**From:** [Keli Bender](#)  
**To:** [Jeff Watson](#)  
**Subject:** Gloria Short Plat  
**Date:** Friday, March 19, 2010 11:19:03 AM

Re: SP-10-00001

RE: Gloria Short Plat SP-10-00001

TO: Jeff Watson, Community Development Services  
FROM: Christina Wollman, Planner II *CW*  
DATE: February 24, 2010  
SUBJECT: Gloria Short Plat SP-10-00001

GLORIA SHORT PLAT  
PART OF SECTION 29,  
T. 18 N., R. 19 E., W.M.  
KITITAS COUNTY, WASHINGTON

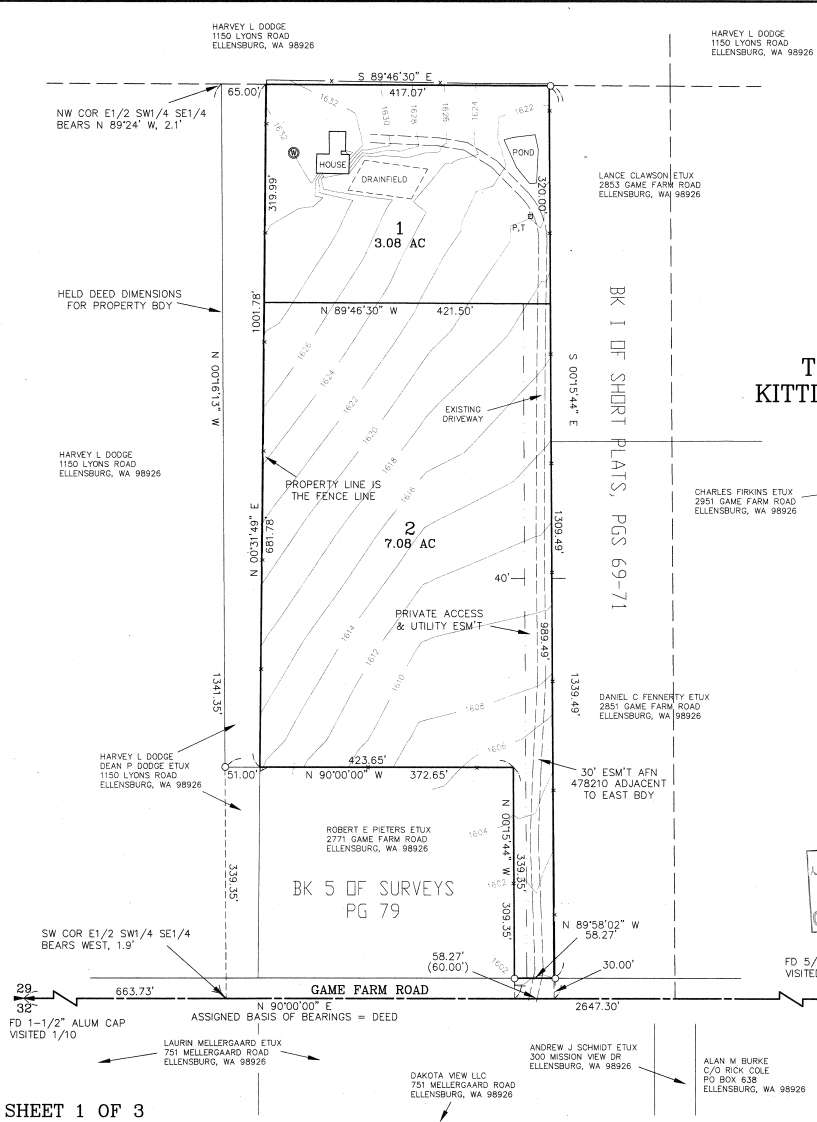
1. The fire department access road to be 20' wide and capable of support 75,000 lbs with an all-weather surface.
2. The addresses need to be clearly visible from both directions at the county road for all properties.
3. The fire flow requirements for residential development is listed at 1500 gpm for 2 hours in Appendix B of the 2006 IFC.

1. Joint-Use Driveway: A joint-use access shall serve no more than two tax parcels. See Kittitas County Road Standards, 9/6/05 edition.
  - a. Access easements shall be a minimum of 20' wide. The roadway width shall have a minimum width of 12'.

- b. The surface requirement is for a minimum gravel surface depth of 6".
  - c. Maintenance of driveway approaches shall be the responsibility of the owner whose property they serve. The County will not maintain accesses.
